**RE: Quik Trip Store #7001
521 Unser Blvd NW
Conceptual Grading & Drainage Plans
Engineer's Stamp Date: 05/31/24
Hydrology File: K10D071**

Based upon the information provided in your submittal received 06/04/2024, the Conceptual Grading & Drainage Plans are preliminary approved for action by the Development Facilitation Team (DFT) on Site Plan for Building Permit.

Re: QuikTrip 7001, Albuquerque
Matkin Hoover Job No. 7001.01
Hydrology File No. K10D070

SHEET TITLE:
GRADING PLAN SOUTH

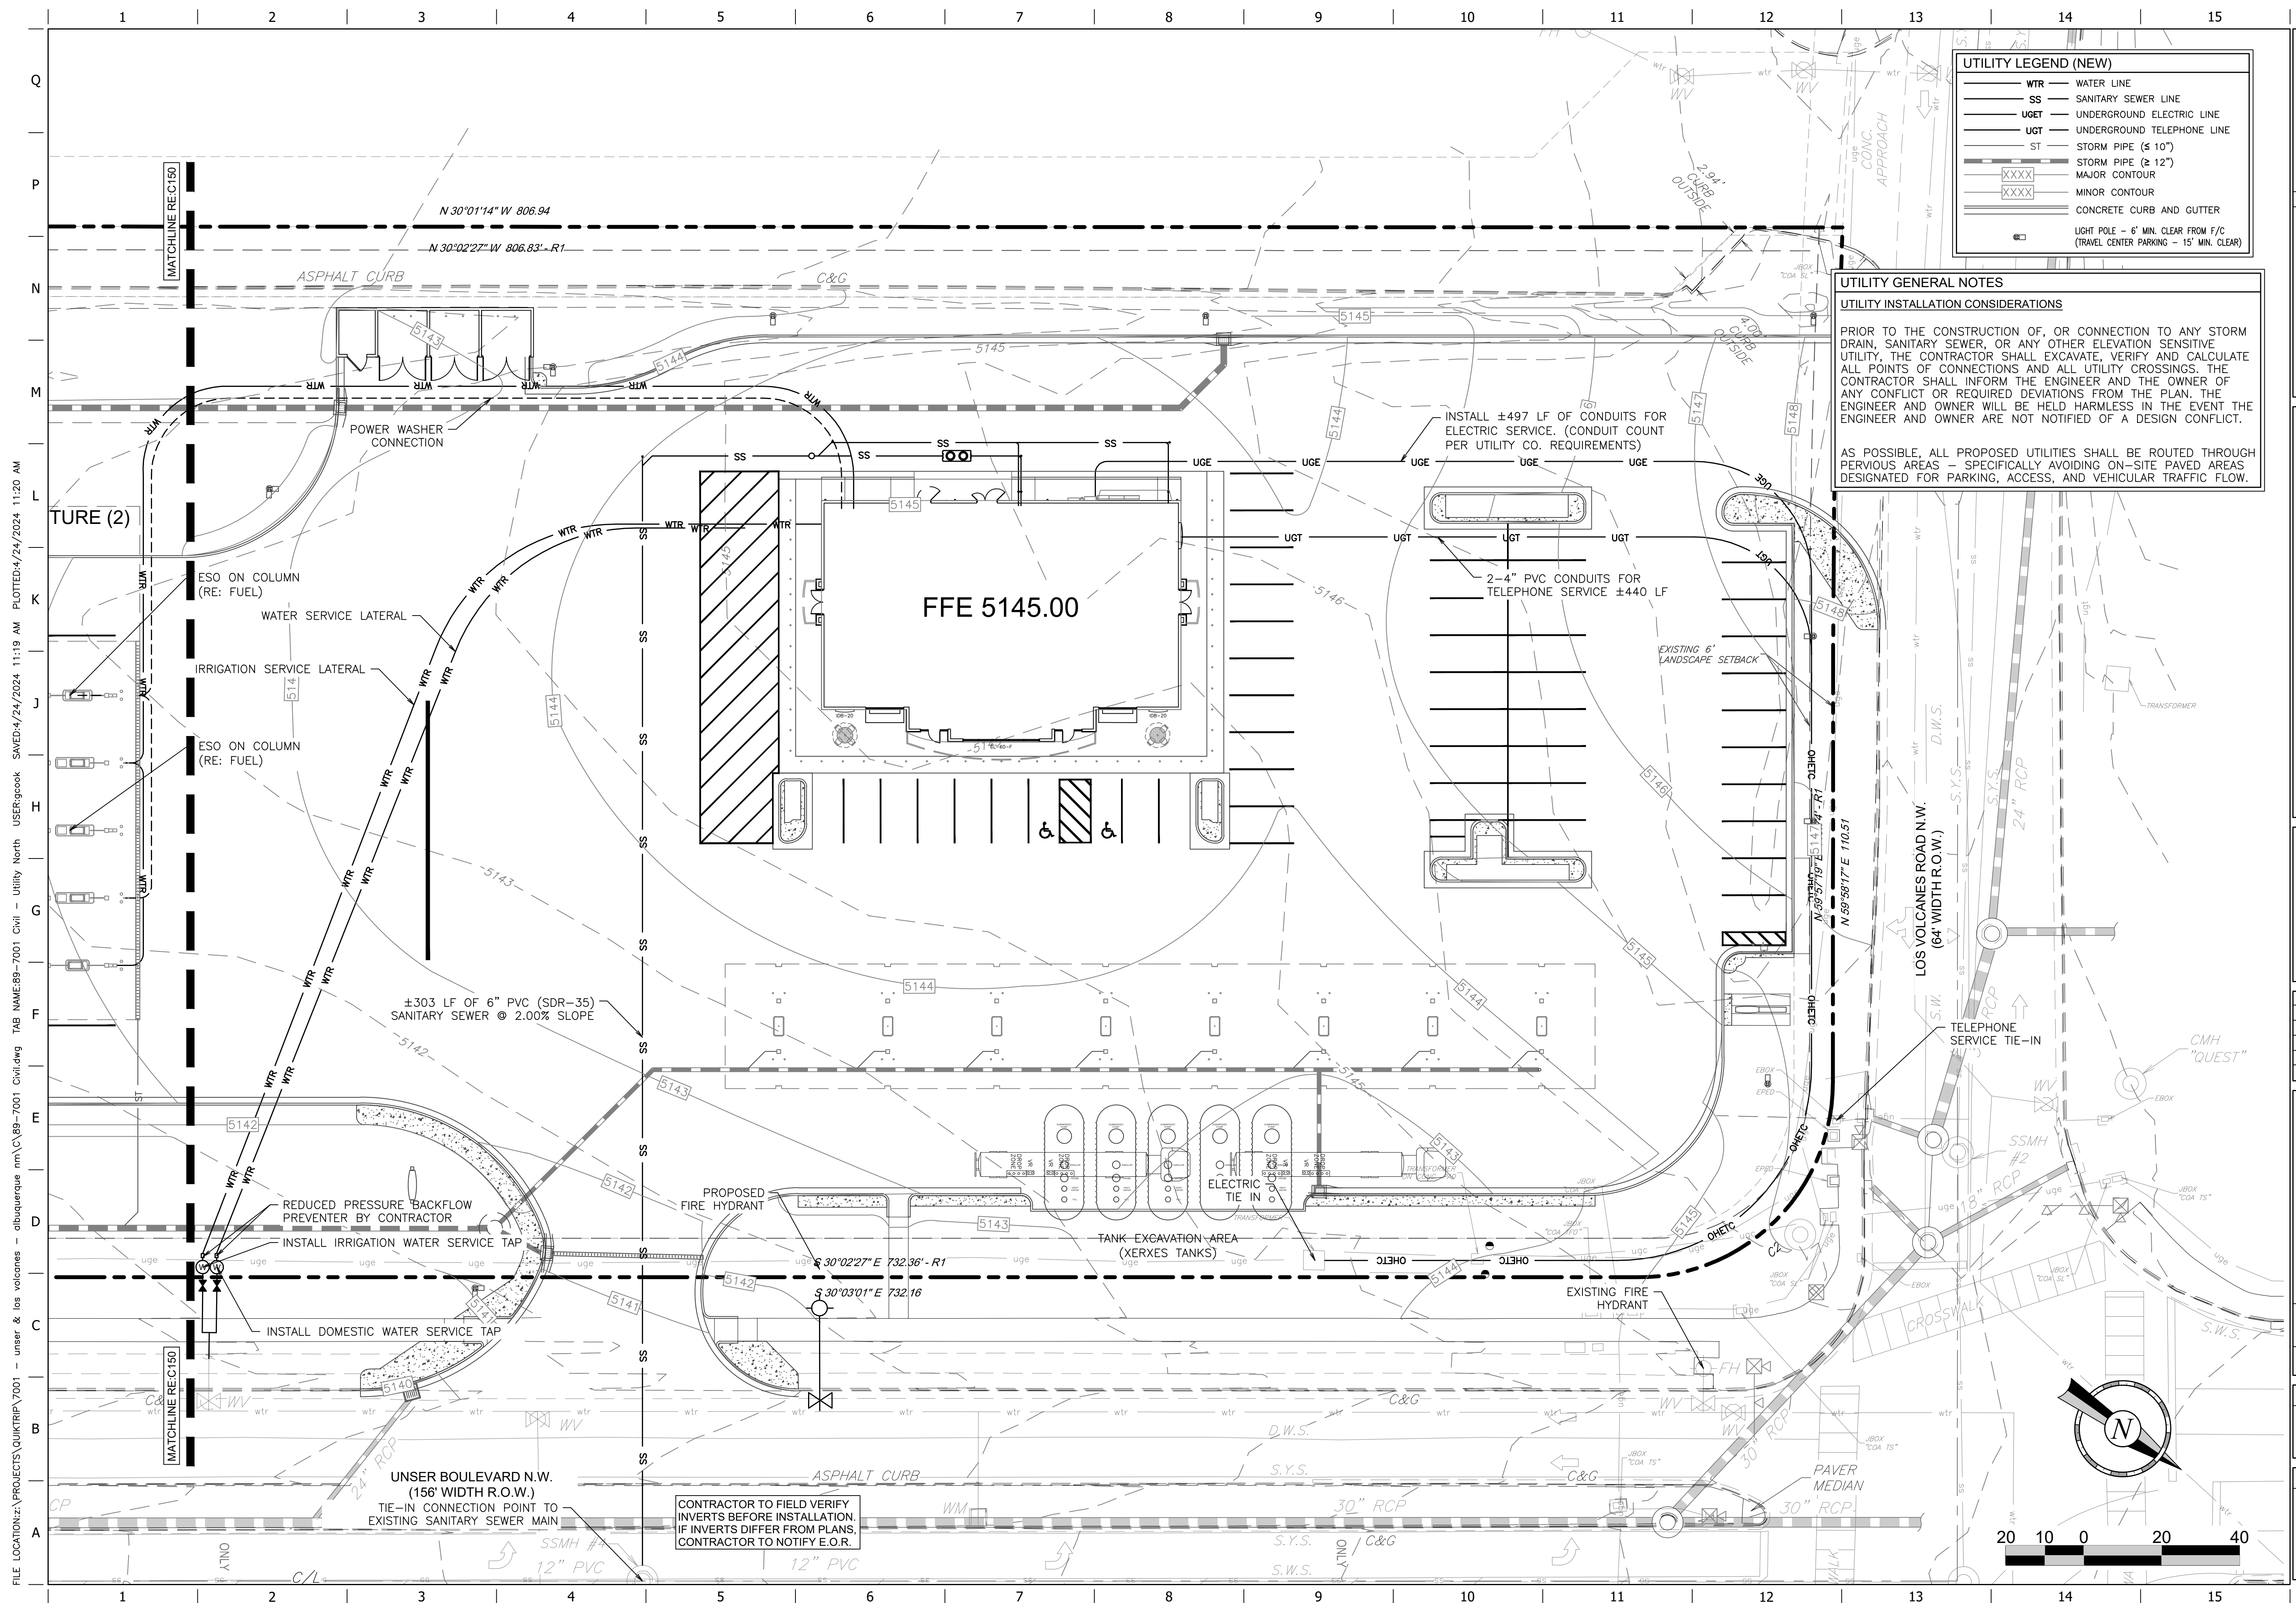
Please number the ponds and include a label on each with the SWQV and elevation, the 100-year volume and elevation, the peak 100-year inflow and outflow, the spillway crest elevation, the spillway flow depth, and the dam top elevation.

All gas stations must drain to an oil/water separator (the Owner's choice) prior to discharge. This is mainly for the area around the pumps, so some previous stations have placed this prior the remainder of the runoff going into the Stormwater quality pond. Since this site appears to be collected in a pipe system, instead of a manhole, this can be an oil/water separator.

Please include the proposed pipe sizes on the Conceptual Grading & Drainage Plans.

BMP Inc. 24F snout added. Callout added to relevant sheets.

Proposed pipe size length and diameter added to all grading sheets.
